Re: Sunport Apartments
Mulberry & Bethel
Lots A1 thru F1 & Lots 1A, Block 10, Unit 3
Traffic Circulation Layout
Engineer's/Architect's Stamp 11-29-18 (M15D036)

Based upon the information provided in your submittal received 11-29-18, the above referenced plan cannot be approved for Building Permit until the following comments are addressed:

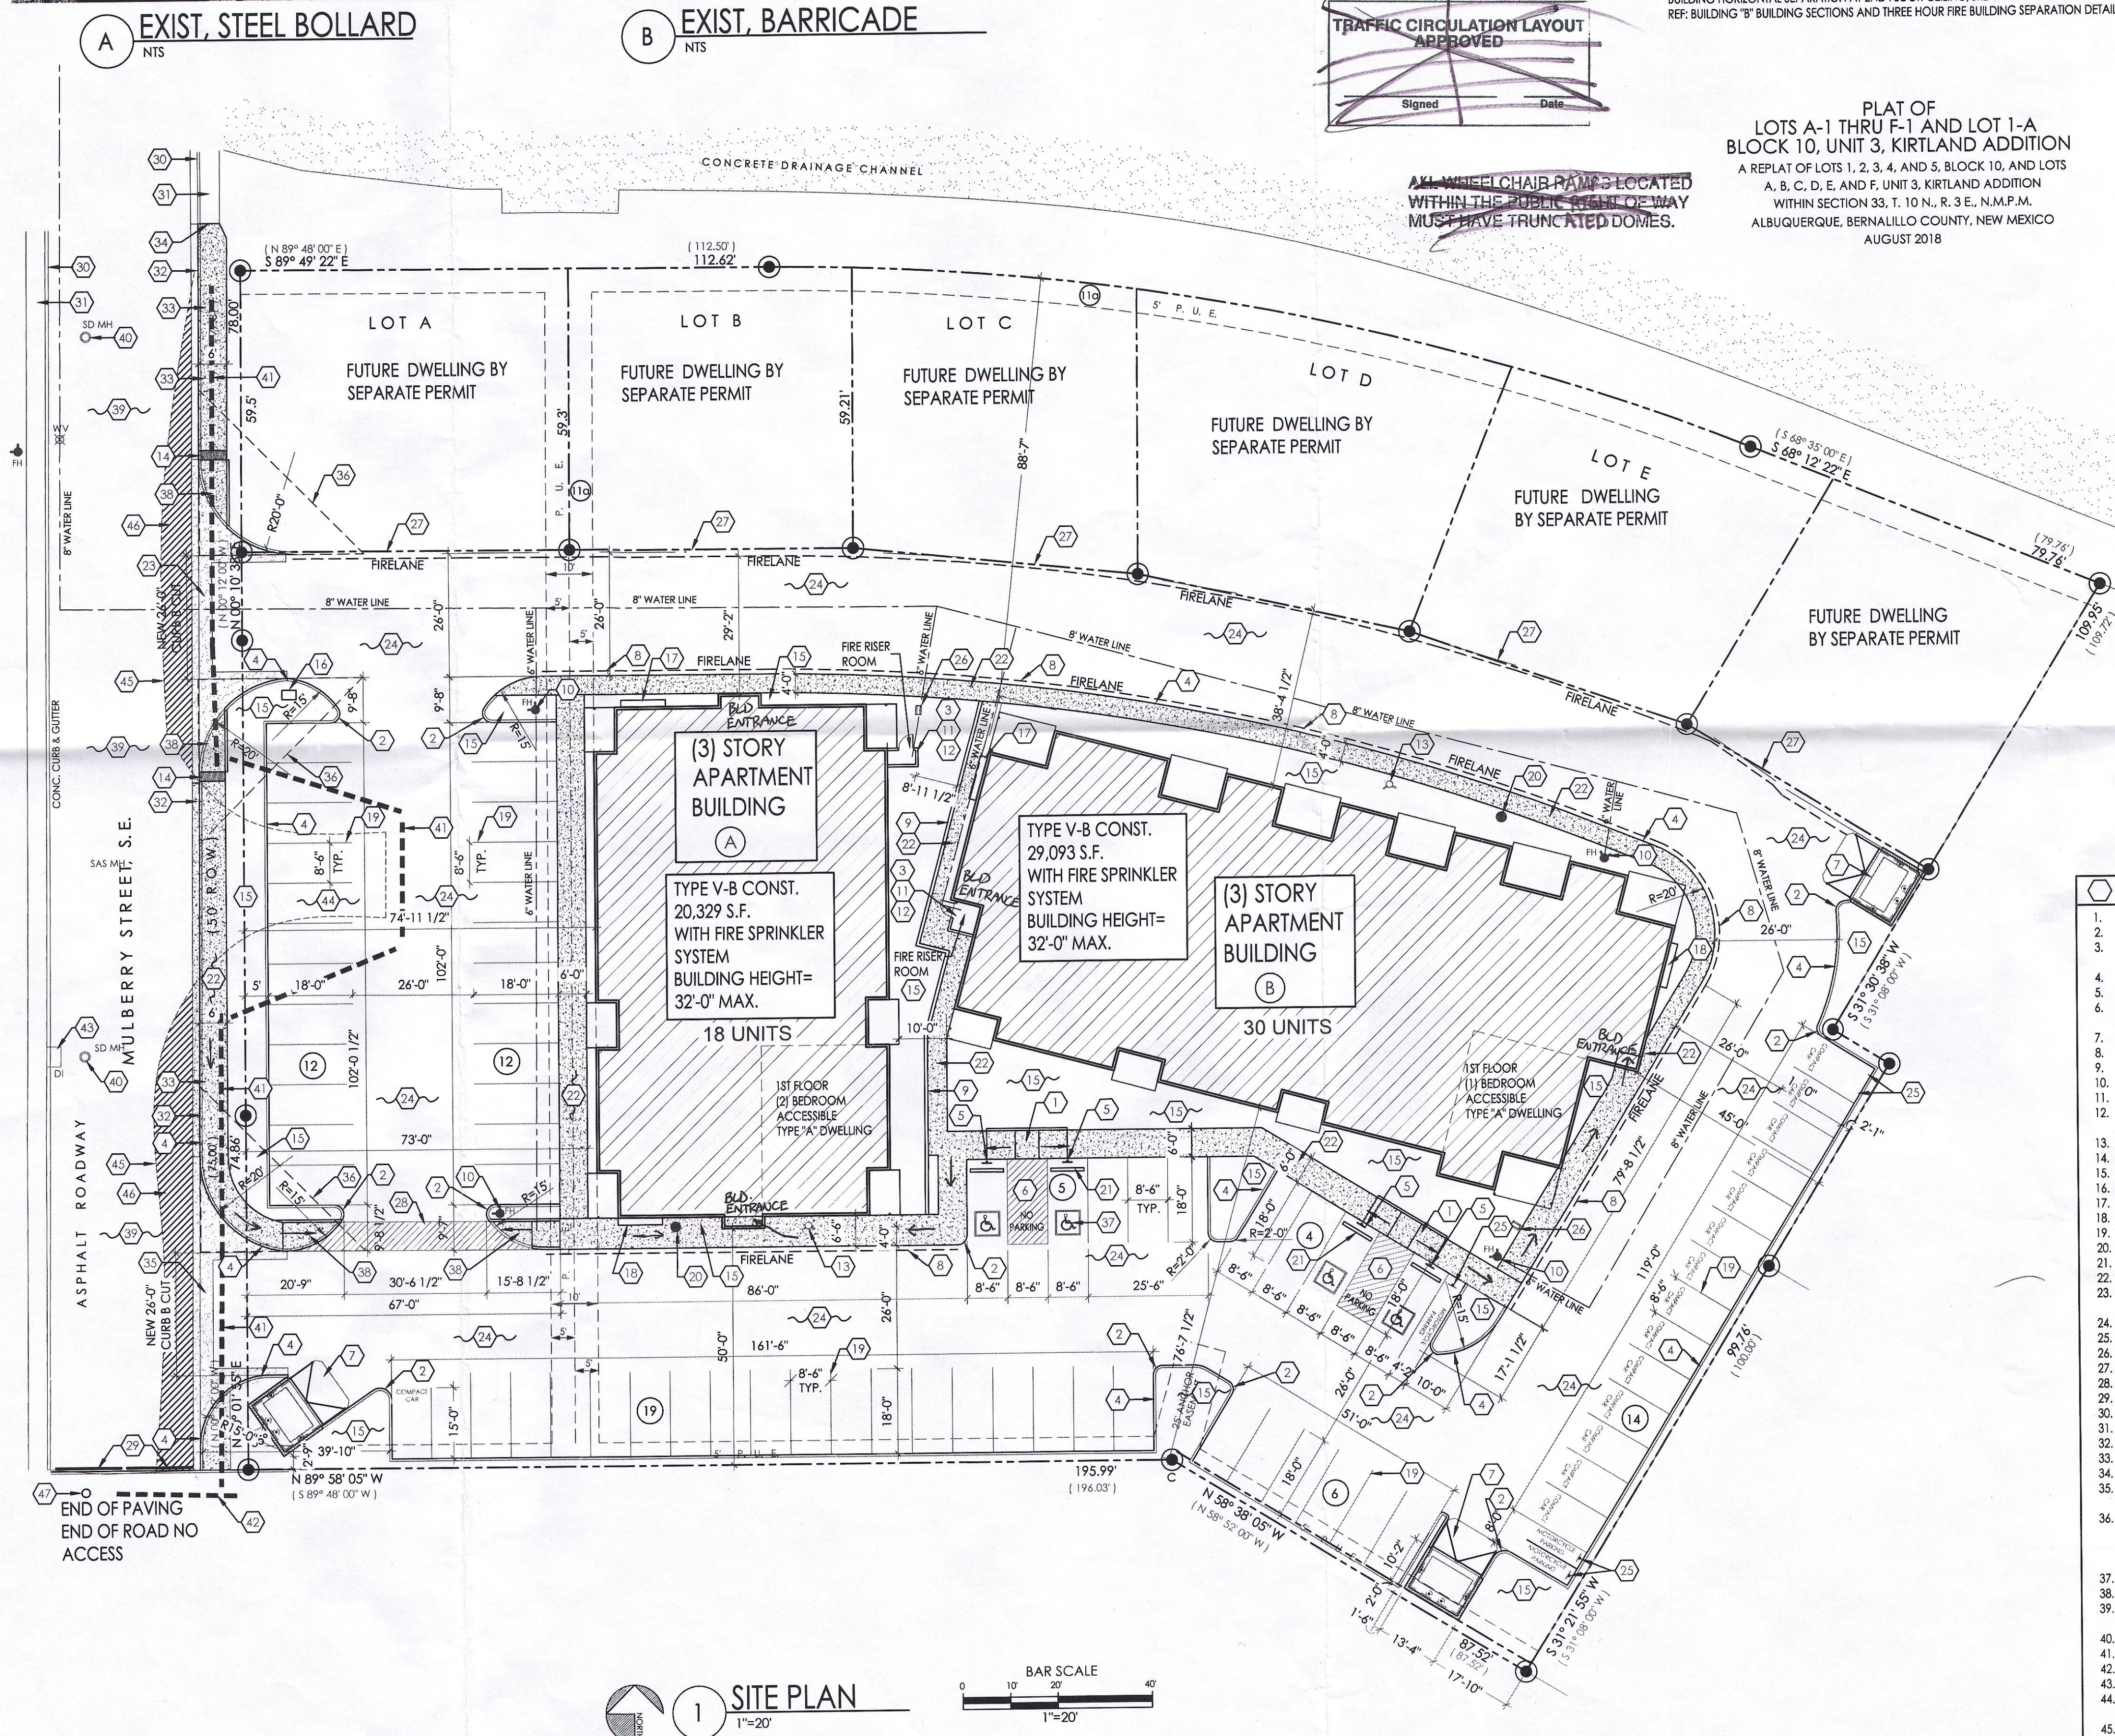
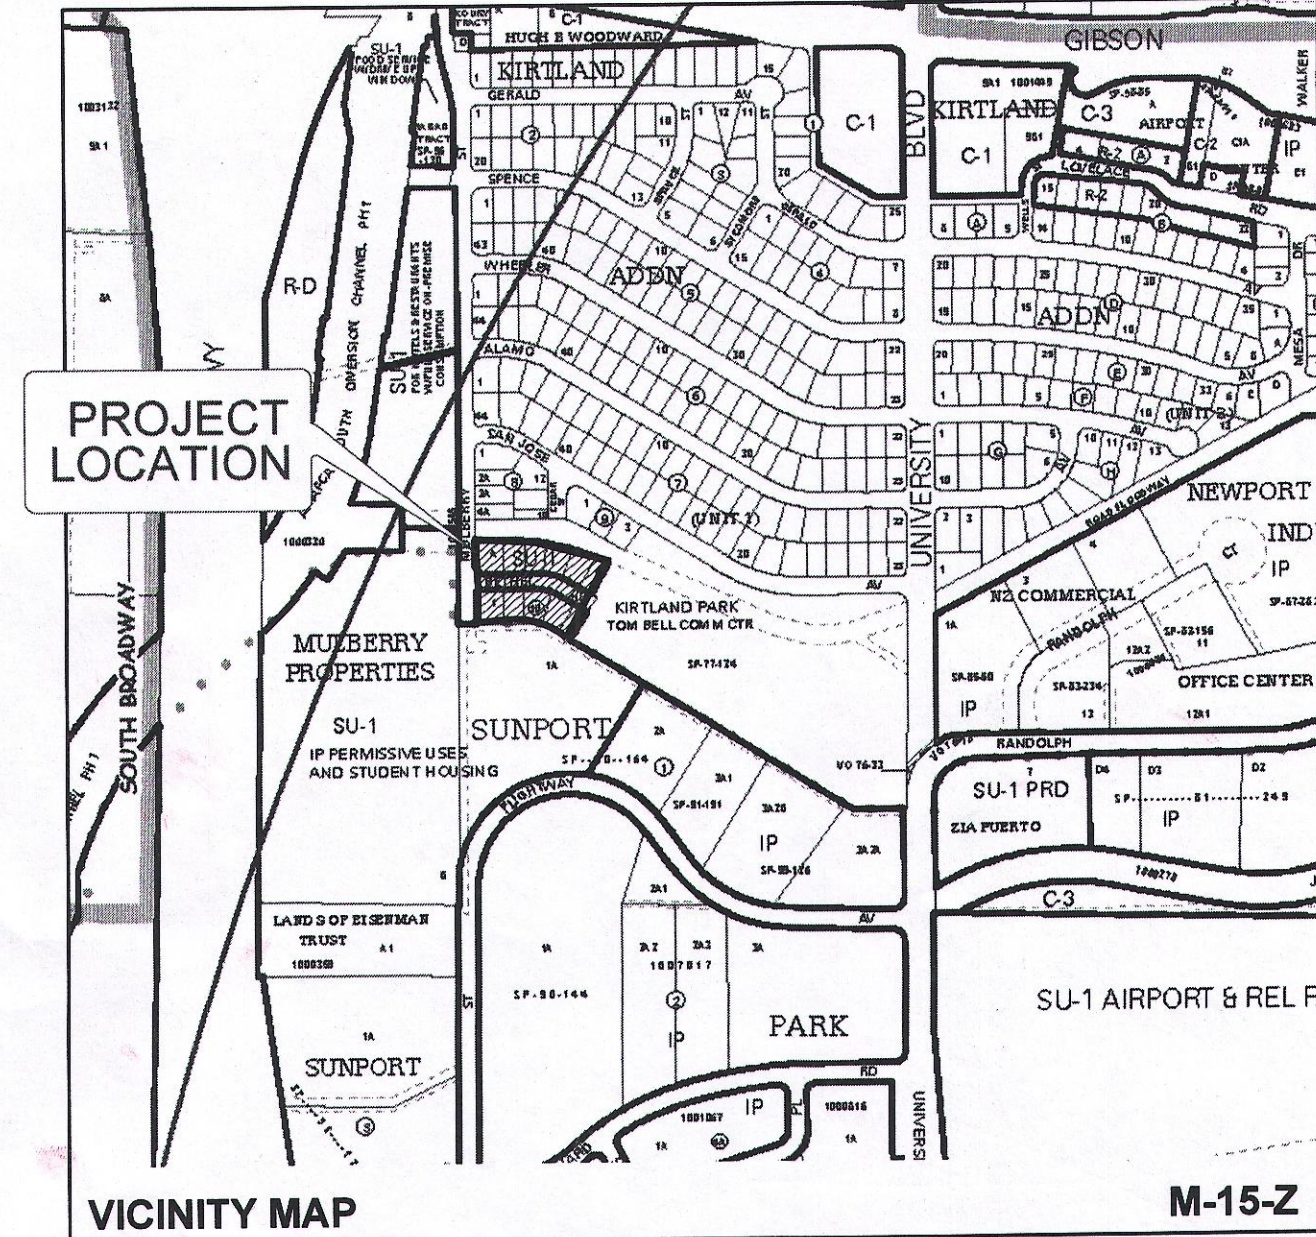
1. List the number of parking spaces required by the zoning code as well as the proposed number of parking spaces including bicycle and motorcycle parking.
2. The scale must be shown on the plan. Per the Development Process Manual, Chapter 27, Section 2, Part B.1, on the following scales may be used:

$1" = 20'$
 $1" = 40'$
 $1" = 100'$ (for overall layouts only)
3. Per the IDO, a 6 ft. wide ADA accessible pedestrian pathway is required from the public sidewalk to the building entrances. Please clearly show this pathway and provide details.

4. Per DPM, a 6 ft. wide ADA accessible pedestrian pathway is required from the HC parking stall access aisles to the building entrances. Please clearly show this pathway and provide details.

5. ADA accessible pedestrian pathway should not be placed behind parking space or adjacent to a vehicular way. Vehicle and pedestrian/wheel chair conflicts should be avoided as much as possible.

6. Please provide a sight distance exhibit
7. Show the clear sight triangle and add the following note to the plan:
"Landscaping and signage will not interfere with clear sight requirements. Therefore, signs, walls, trees, and shrubbery between 3 and 8 feet tall (as measured from the gutter pan) will not be acceptable in the clear sight triangle."

8. Please specify the City Standard Drawing Number when applicable.

9. Provide notes showing what work is included and on the work order and the private work on site.
10. Work within the public right of way requires a work order with DRC approved plans.
11. Please add a note on the plan stating "All improvements located in the Right of Way must be included on the work order."
12. Please clarify Key Note #2 is referencing correct location on site plan.
13. Please include one copy of the traffic circulation layout at the next submittal.
